From: Laura Gibbons
Sent: 03 October 2018 16:19
To: Planning.Responses
Subject: RE: Planning Consultation on: M/114/18/PL

Engineers Comments Regarding Surface Water Drainage

APPLICATION NO: M/114/18/PL

Site Address: 5 Central Drive Middleton-On-Sea PO22 7TT

SITE BLOCK PLAN 1:500

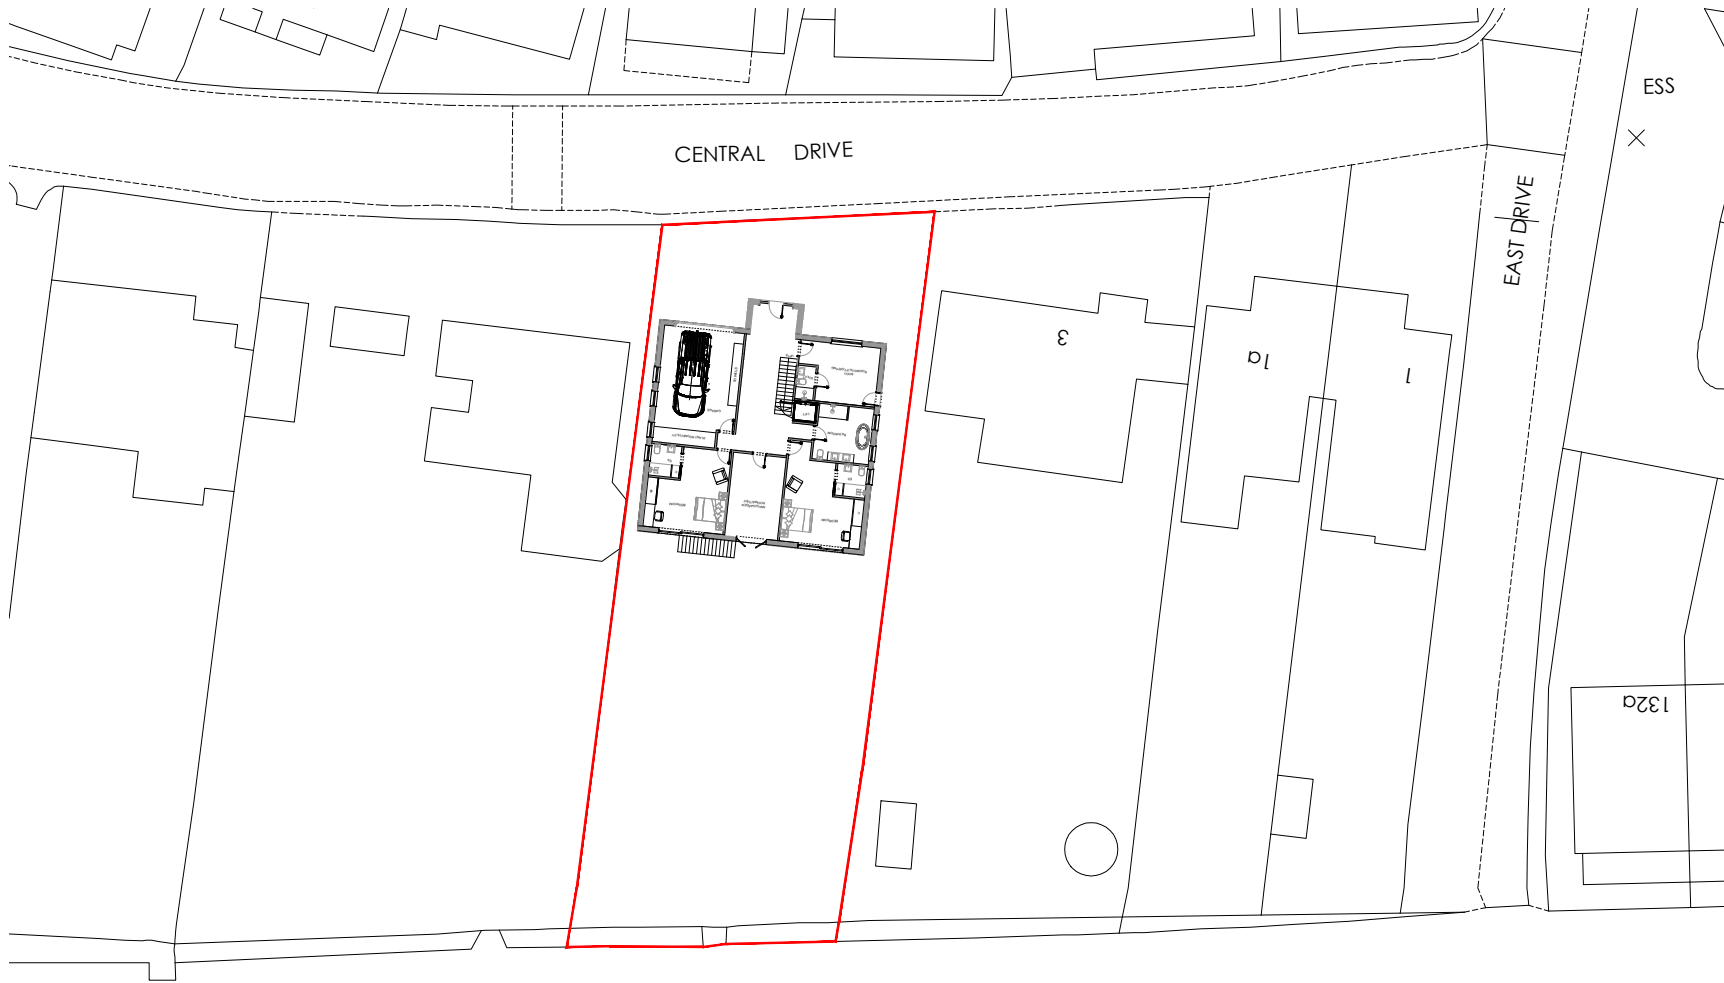
The proposals are for a Geocellular soakaway to be located in the rear garden, this should work in principal. However the full testing and design needs to be completed as detailed above.
